Date: 8 July 2026
PINS Ref: EN0710010
Our Ref: 17996

EN0710010 – EAST COAST HYDROGEN TEESSIDE PIPELINE (NORTHERN GAS NETWORKS)

We write on behalf of Net Zero North Sea Storage ('NZNSS'), in respect of Northern Gas Network's ('NGN' / the 'Applicant's') proposed development consent application for the East Coast Hydrogen Teesside Pipeline Project (the 'ECH Teesside Project'). NZNSS is an undertaker for the purposes of the development consent order granted in respect of the Net Zero Teesside Project.

Drawing Title
Figure 1.2 - The Scoping Boundary

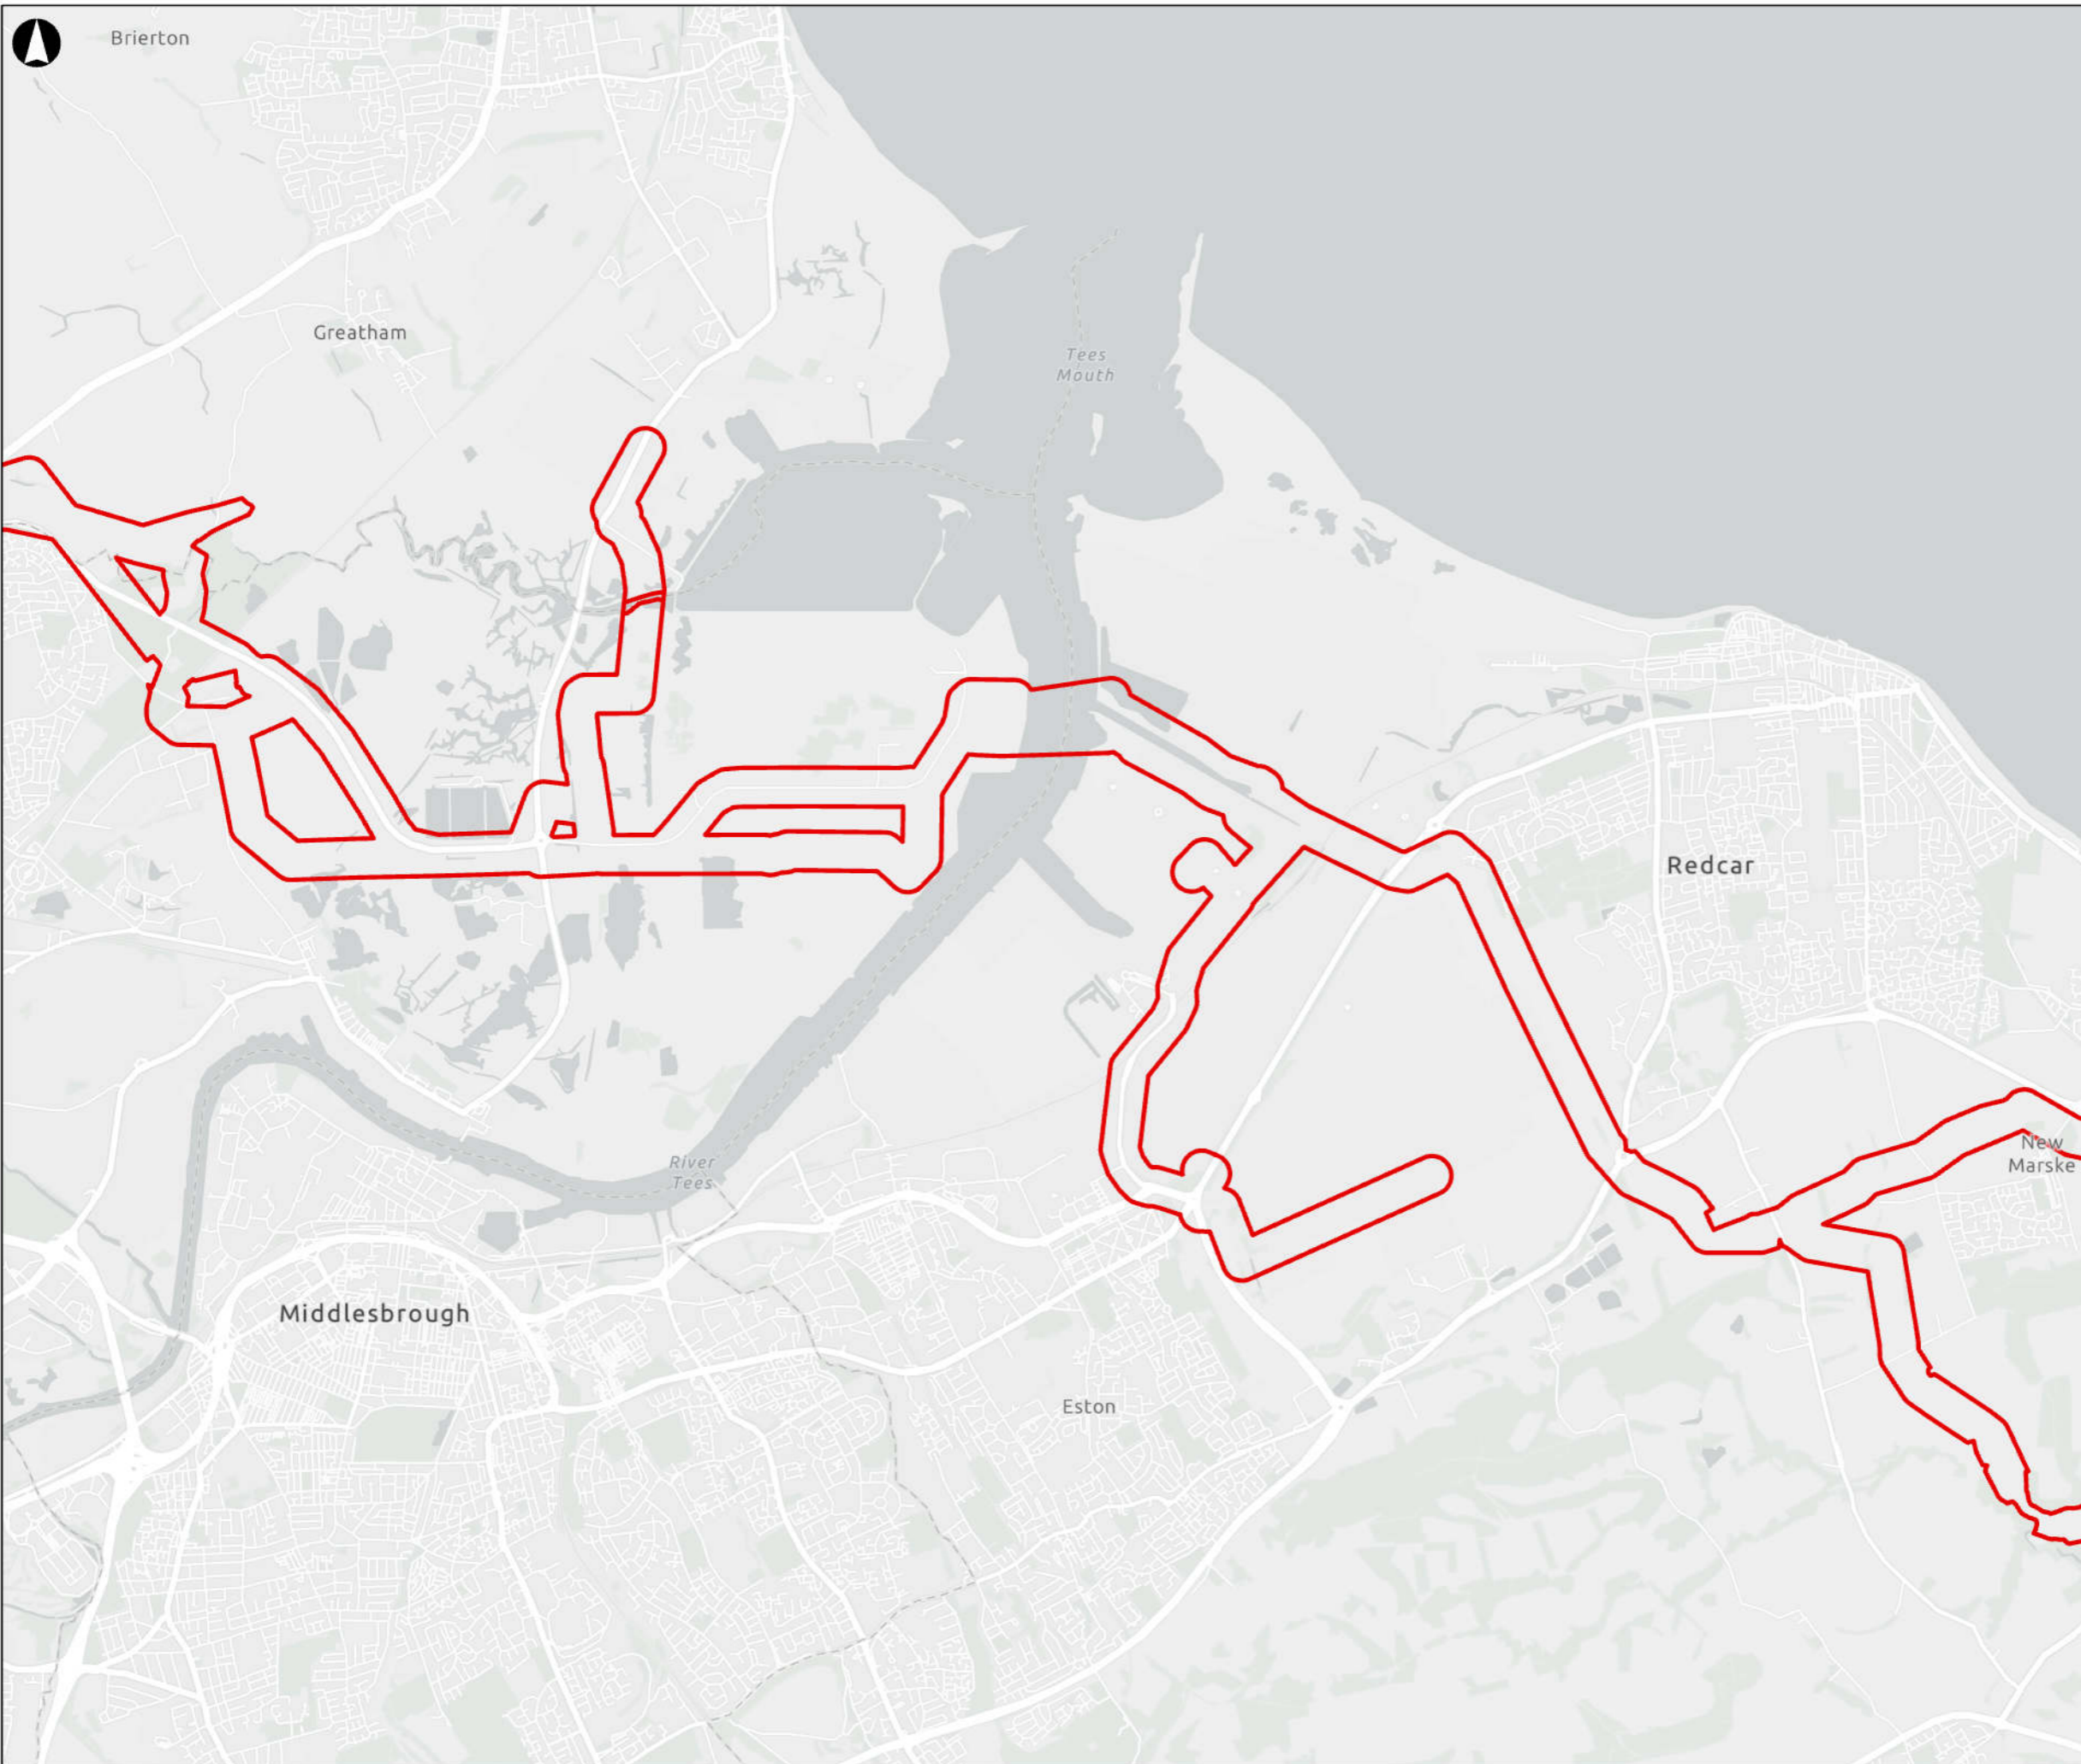
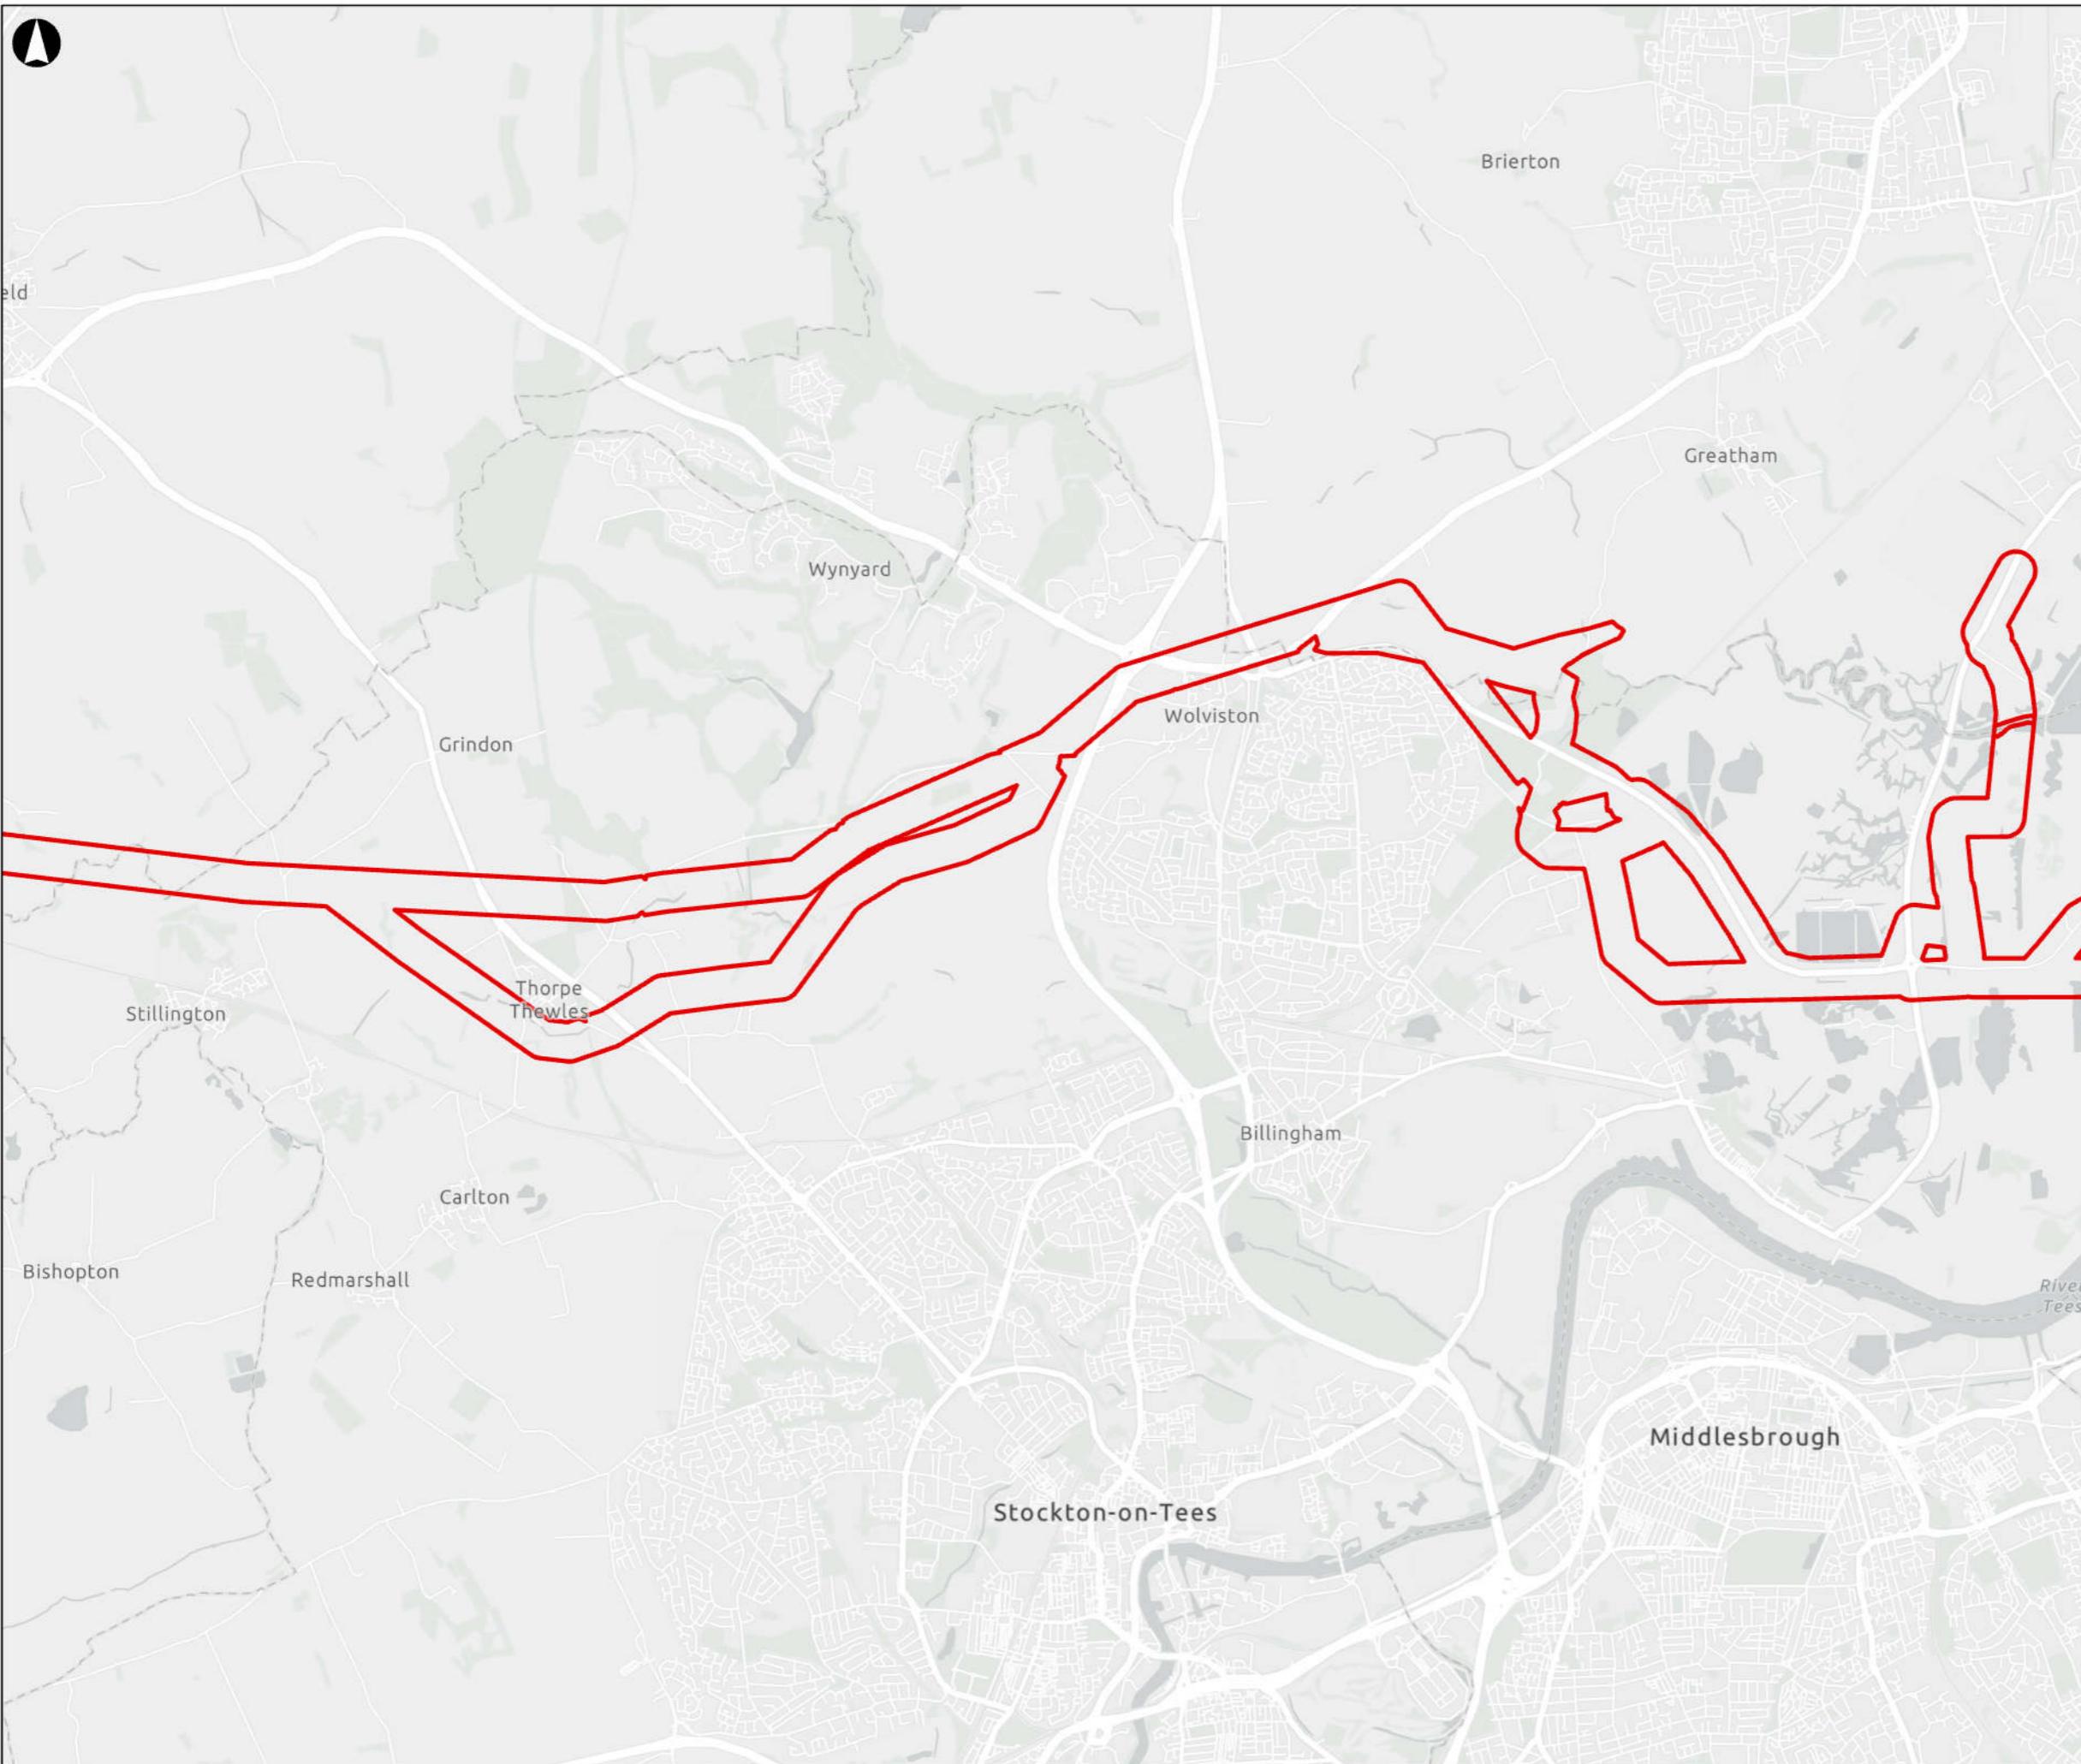
NZNSS notes that NGN has submitted an application for an Environmental Impact Assessment ('EIA') scoping opinion in respect of the ECH Teesside Project to the Secretary of State for Energy Security and Net Zero. We have reviewed the EIA Scoping Report, notably Figure 1.2 (Rev P01) and Figure 1.3 (Rev P01) which show the Scoping Boundary, and Figure 4.1 which shows the Indicative Site Layout, and wish to make you aware of the interactions and overlaps of those with the confirmed Order limits for the Net Zero Teesside Project.

It is evident from a review of the ECH Teesside Project's EIA Scoping Report and the NZT Works Plans, that there are significant interactions and overlaps between NGN's Scoping Boundary (Figures 1.2 and 1.3) and the NZT Order limits for the NEP Project. In particular, the proposed Scoping Boundary for the ECH Teesside Project, includes land that is within (or is in close proximity to) the carbon dioxide gathering network (Work No.6); and above ground installations (Work No. 6A) within the confirmed Order limits for NZT.

Having regard to the above, it is crucial that the Order limits for the NEP Project are taken into account by NGN in undertaking its EIA of the ECH Teesside Project, and that the ECH Teesside Project does not impact on the delivery of the NEP Project given its importance within the ECC. It will be of significant interest to NZNSS as to how the Applicant plans to install the infrastructure comprising the ECH Teesside Project while protecting, and facilitating ongoing future access to NEP's infrastructure. NZNSS is also concerned that the ECH Teesside Project may have a safety impact on NEP. Given these
